**KIRKLEES SAFETY AUDIT BRIEF – Internal Audits**

<b>Scheme Name</b>	Rowley Lane S278	<b>Budget Code</b>	50/61868	<b>Lead Designer</b>	Haigh Huddleston & Associates (RSA request Zulqarnain Azam)
<b>Location</b>	Rowley Lane, Fenay Bridge				
<b>Type of Scheme</b>	S278 scheme including new access for housing estate, new uncontrolled crossings, bus stop relocation, revisions to Rowley Lane / A629 junction

<b>General Comments/ Design Criteria/ Summary / Details of last audit (if required):</b>
This also includes any departures from standards
<p>Previous Stage 1 RSA under GG119, details as provided on previous page.</p> <p>This is a S278 scheme aims to improve existing highway condition and propose new junction for a new development and other highway works including, footway, resurfacing and road marking.</p>

SITE ENTRANCE

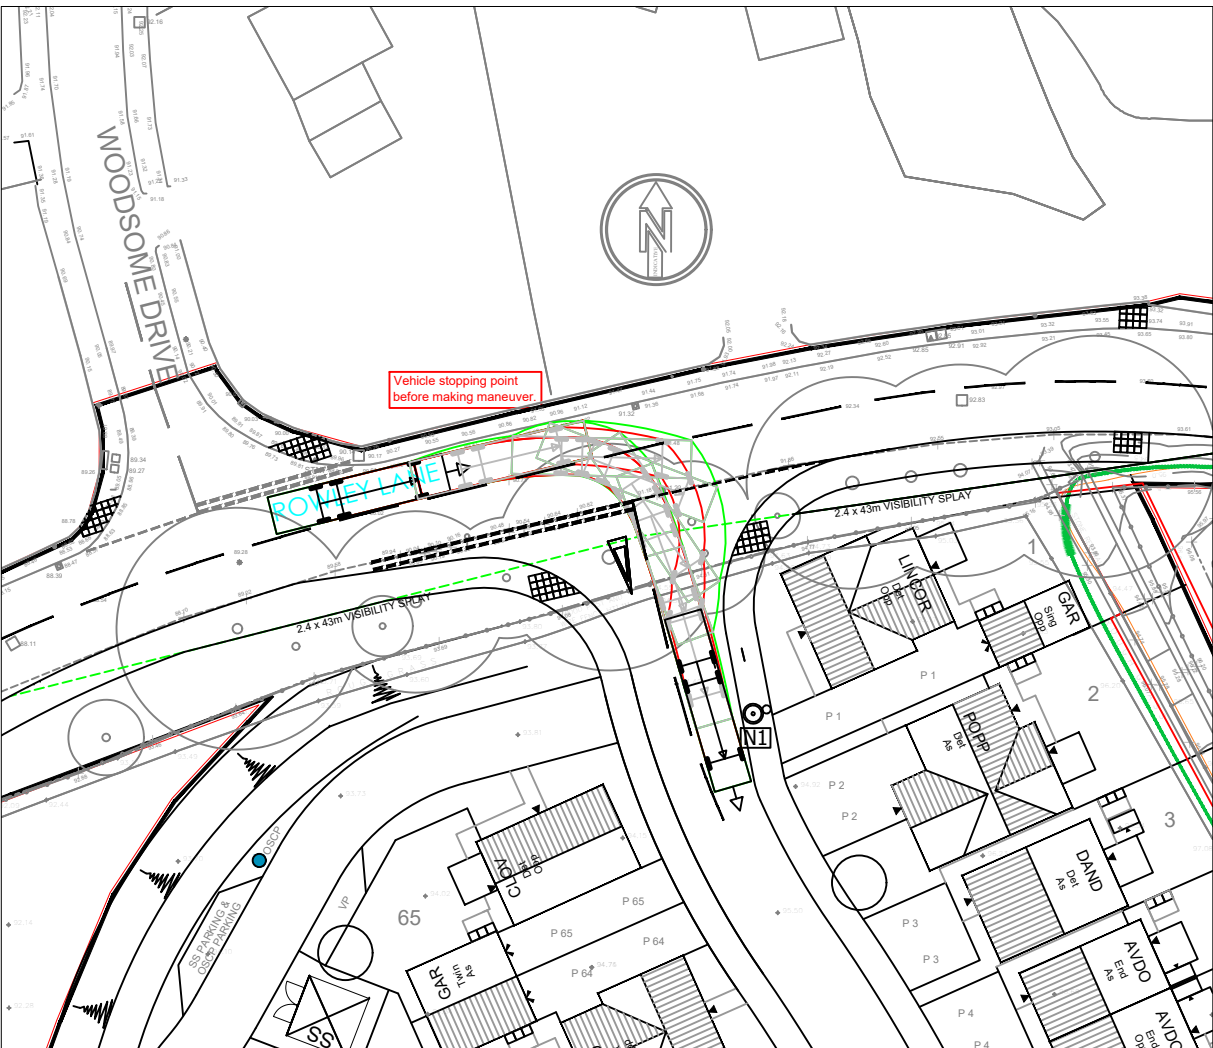
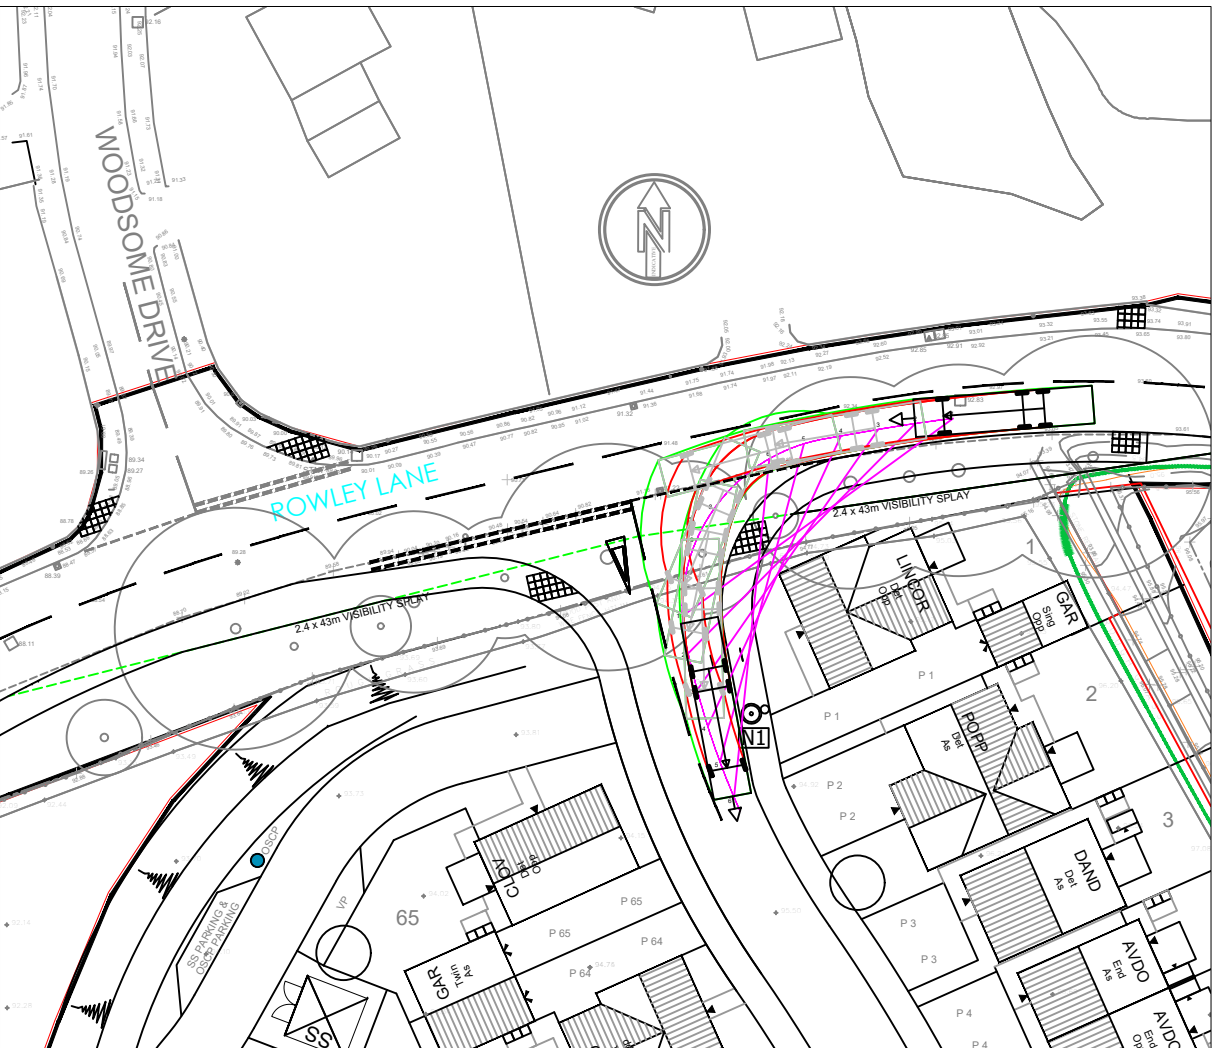
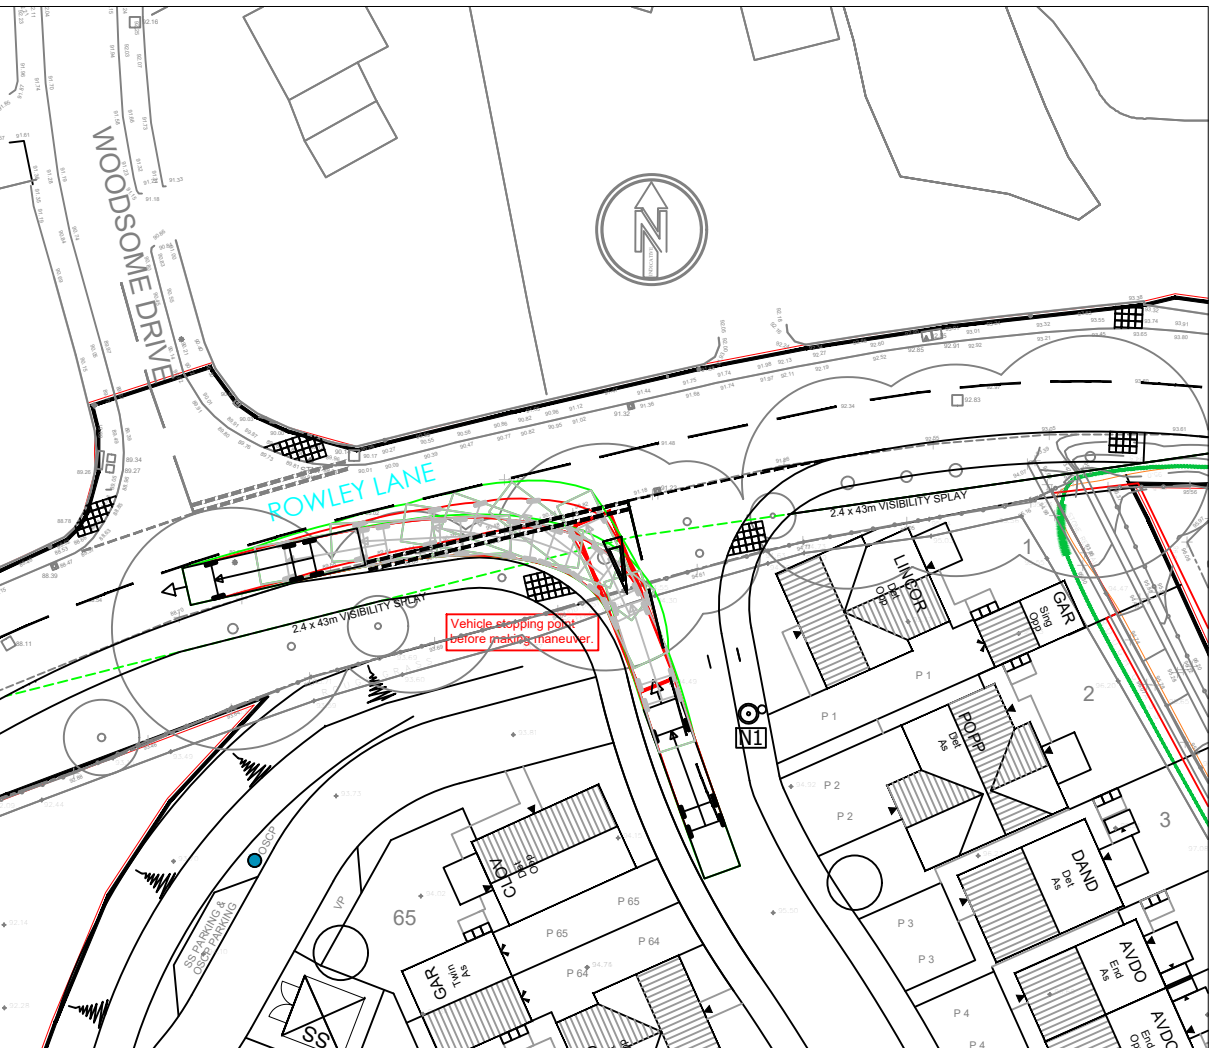
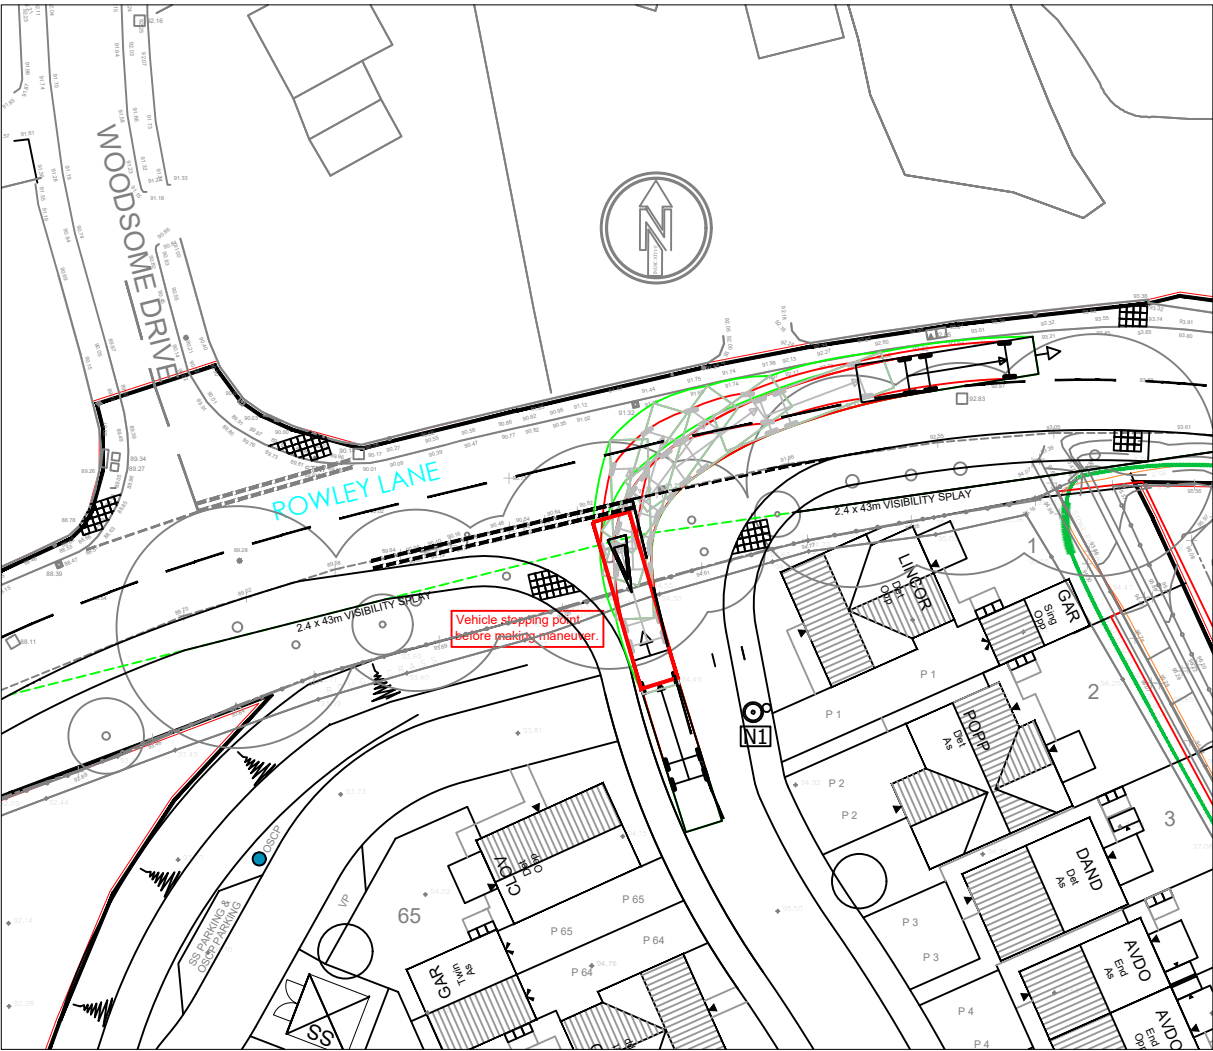
**Problem 2** – Larger vehicles manoeuvring at proposed access would encroach across oncoming lanes, resulting risk of collisions and injuries

The swept paths show encroachment across oncoming traffic lanes by the Refuse vehicle executing all manoeuvres, but especially left turns. This increases the likelihood of collisions and injuries when opposing traffic is present. Although refuse vehicles may only visit occasionally, there would be similar levels of encroachment by *any* large vehicle, and deliveries (for example) could be frequent.

It is recommended that junction geometry is eased. One option would be to provide 1m x 10m tapers for the trailing edges of left turning vehicles (which would also reduce lane overrun by larger vehicles turning right in).

Width / crossing distance through the junction mouth arising from the addition of tapers would not increase to such a degree that the RSA Team would consider a refuge island necessary (and there would not be adequate room to provide one without significantly changing the layout). Regardless, the numbers of pedestrians crossing through the junction mouth would be extremely low and highly unlikely to carry significant risk, because pedestrians on wider east-west trips would be using the continuous footway along the northern side of Rowley Lane. Crossing movements would be unlikely here other than by residents of the estate.

The problem is unrelated to junction visibility; it concerns restricted space for turning in the junction mouth. It is not reasonable or necessary to expect vehicles turning left-in to the development (for example) to have to stop and wait in the major road whilst another vehicle turns out. With the tapers installed, refuse and delivery vehicles executing turns could do so without conflicting with other traffic within the junction mouth, or on the main road, covering off most traffic scenarios. Whilst issues with lack of space to pass larger vehicles would still occur further south within the estate itself, it is far more important that such issues are not encountered within or close to the junction mouth (where speed differentials are highest with main road traffic), and injury collisions could occur. The changes would also reduce the likelihood of damage to kerbs around the radii. See sketches on following page (based upon unchanged radii with 1m x 10m tapers).

The tapers should be added, or an Exceptions Report provided.

We do not agree with the recommendations of the auditors. An increased junction width would increase the crossing distance for pedestrians resulting in a need for a refuge island. The presence of a central island would make HGV turning much more restricted and worsen the problem.

The existing bank along the southern side of Rowley Lane is to have all vegetation removed and be re-graded to provide an increased visibility at the junction. It is therefore reasonable to expect HGVs to wait until both lanes are clear before making a turn.
